Department of Primary Industries

OUT12/25856

**Macquarie River to Orange Pipeline Project –
Orange Drought Relief Connection (10_0235)
Response to exhibition of Environmental Assessment (EA)**

Macquarie River to Orange Pipeline Project – Response to exhibition of Environmental Assessment Comment by NSW Office of Water

Figure 3: Proposed position of the offtake structure, pumps and associated infrastructure at MR5a on the southern bank of the Macquarie River (Source: MWH).

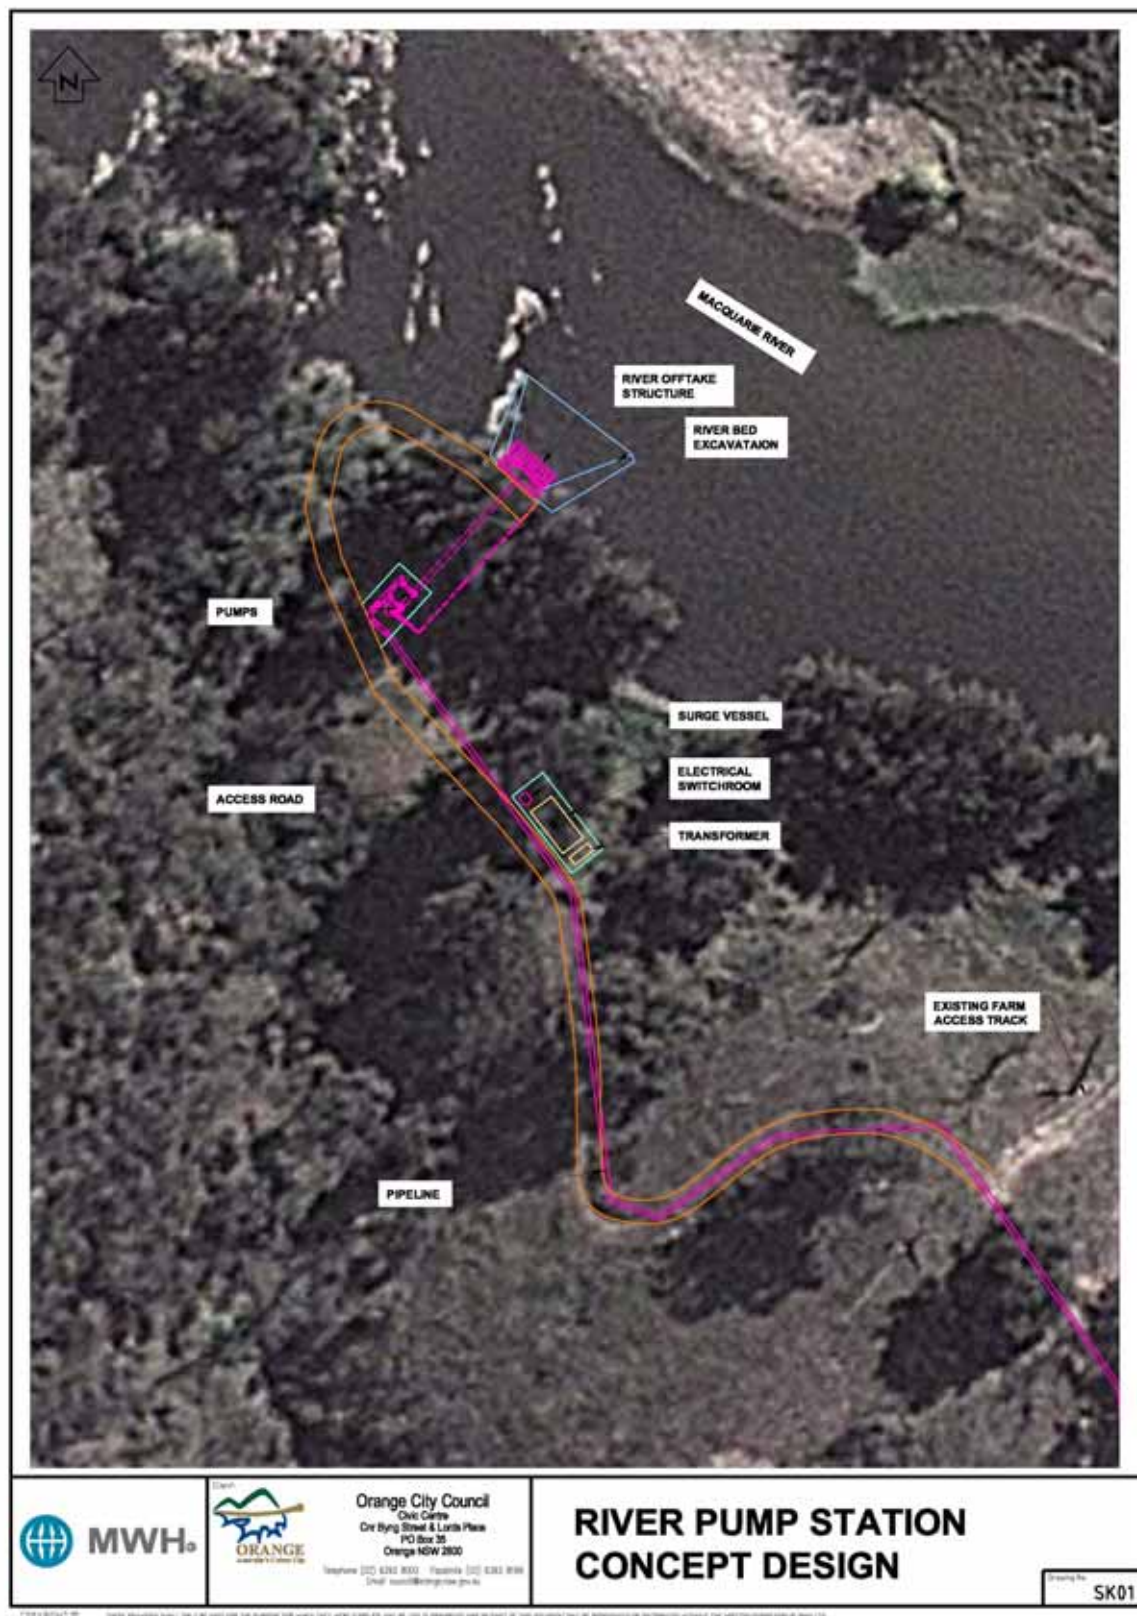
- (i) works within 40m of watercourses including watercourse crossings and off-take installation. The high velocity and potential debris and rock movement in the Macquarie River during high flows represents a significant risk to stability of the off-take structure.

- (i) Fish diversity and abundance (community assemblage) monitoring within the off-take and outside the off-take to gauge the effectiveness of the filter screens and operating efficiency during the operational phase of the pipeline, particularly during the breeding period of listed threatened fish species.
